Ref: 6/2018/2498/LB  
Date: 04/12/2018

## HISTORIC BUILDINGS AND CONSERVATION ADVICE

**RE: 1-5 Park Street, Hatfield, AL9 5AT**

The application is for the change of use of the existing grade II listed building from office (B1) to 4 no. residential flats (C3) with associated internal and external alterations.

Proposed entrance hall party wall panelling

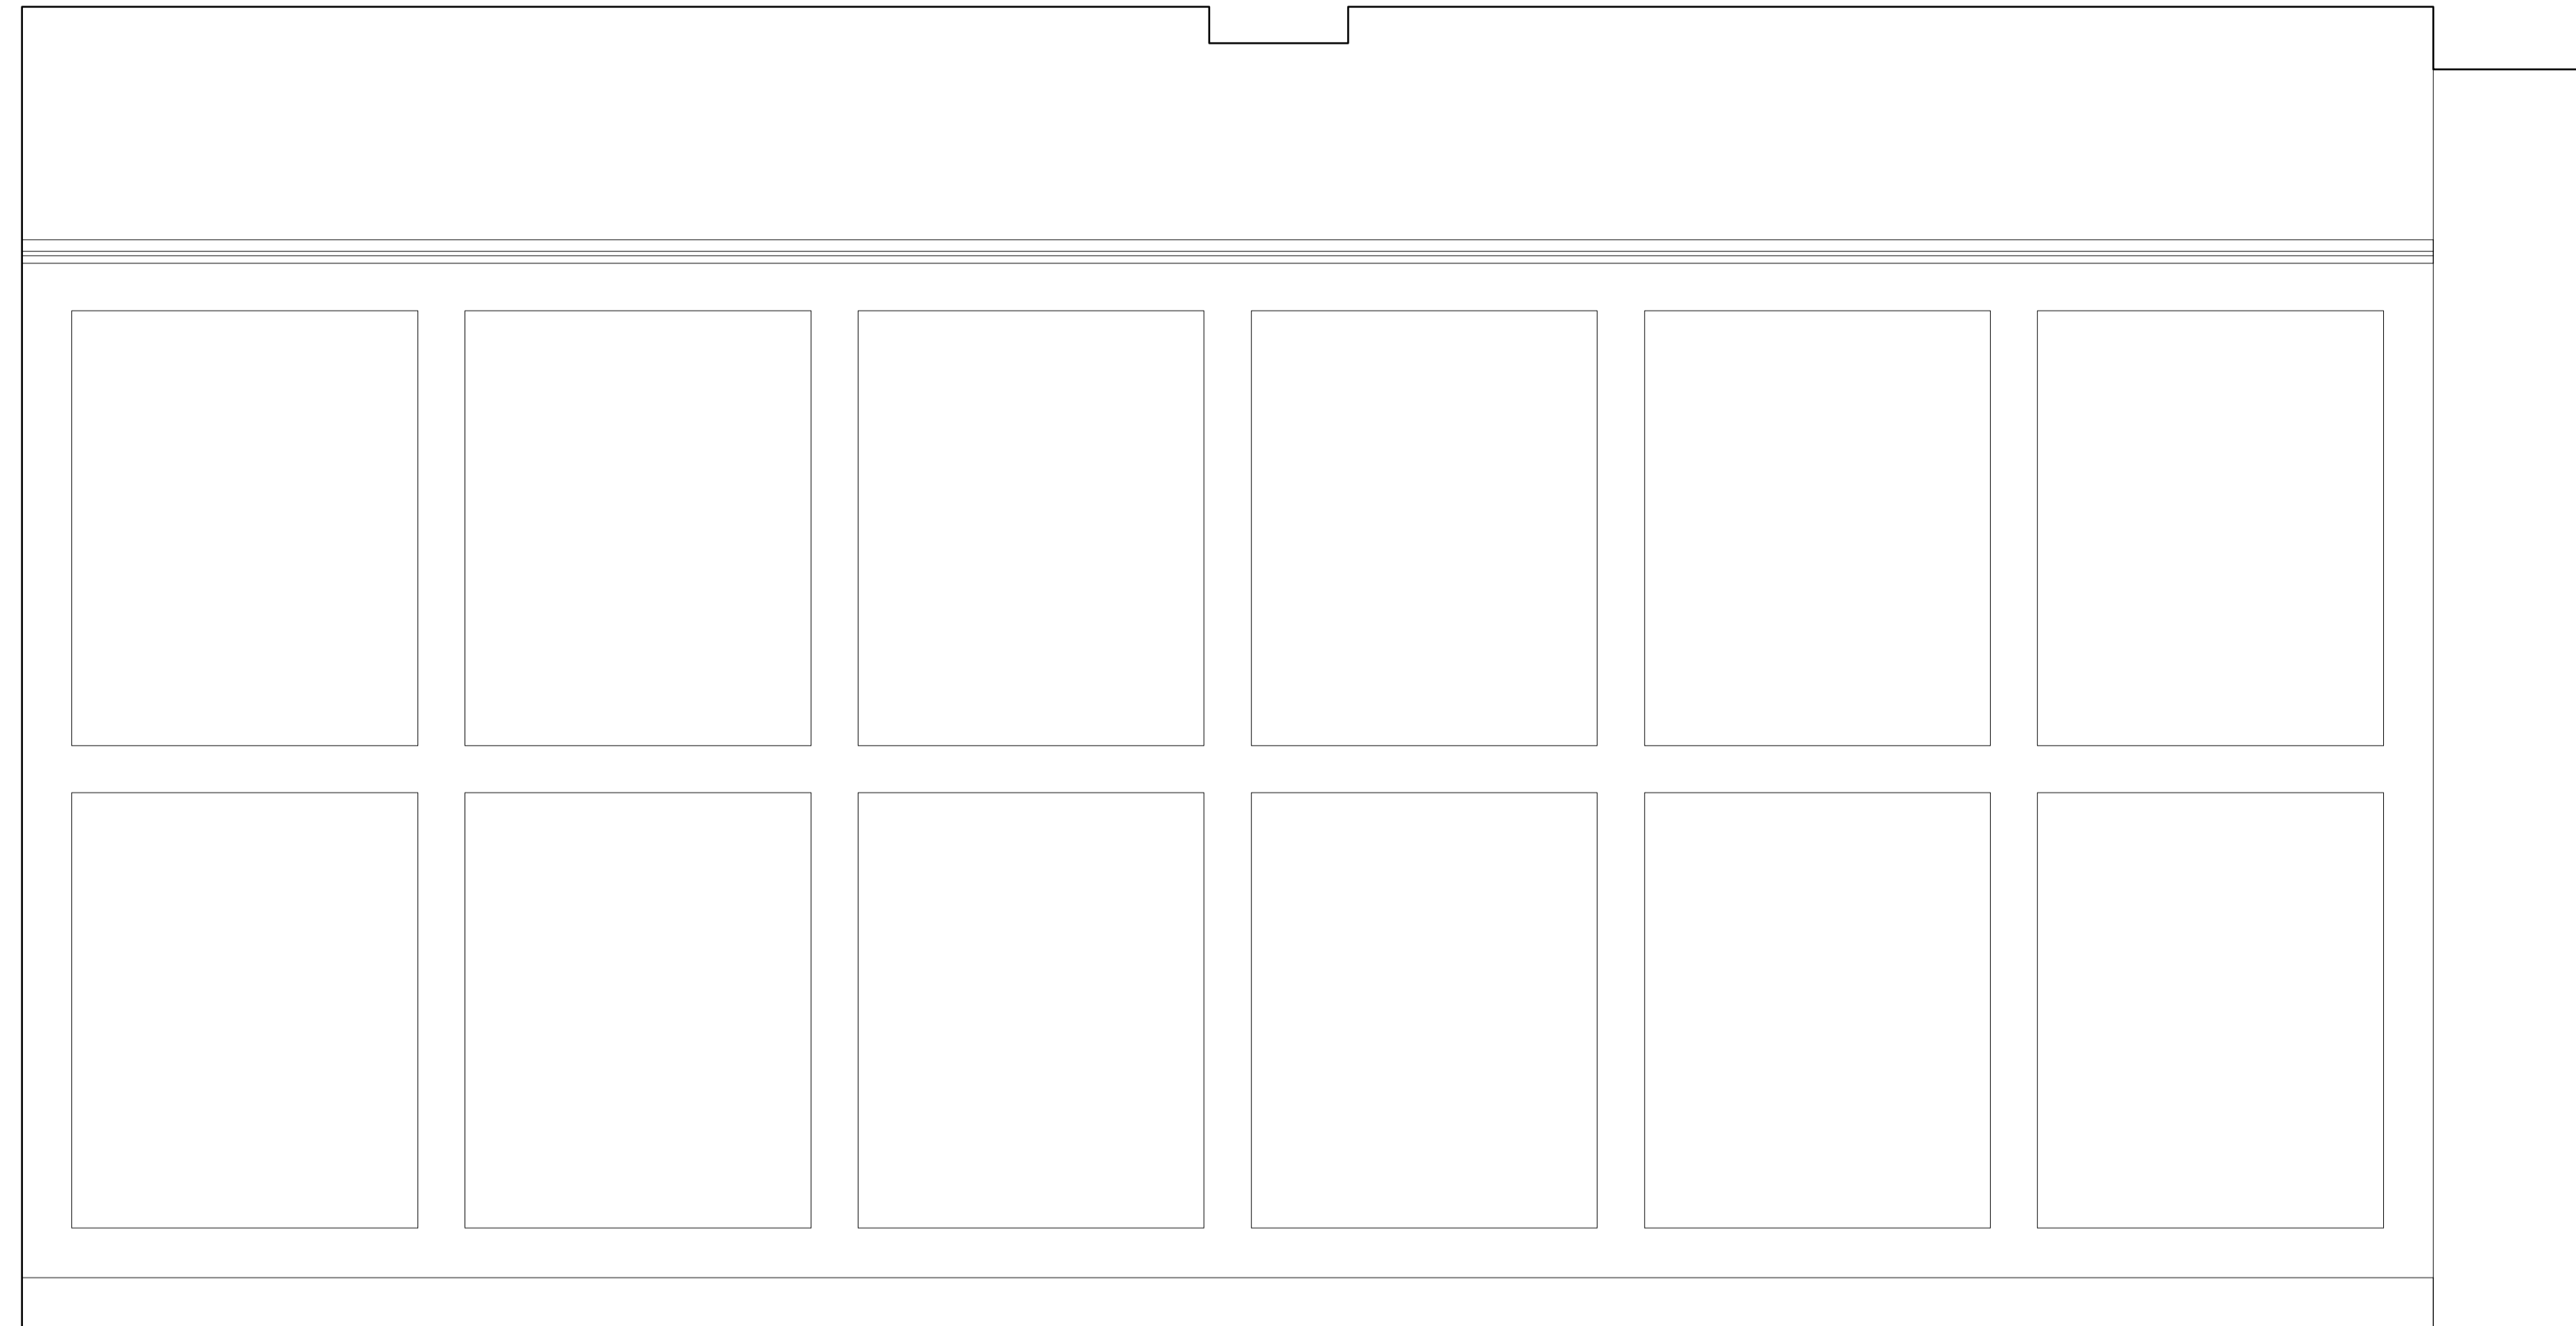
Details of the proposed ground floor hallway wall, first floor job door and ceiling and wall treatments have already been provided.
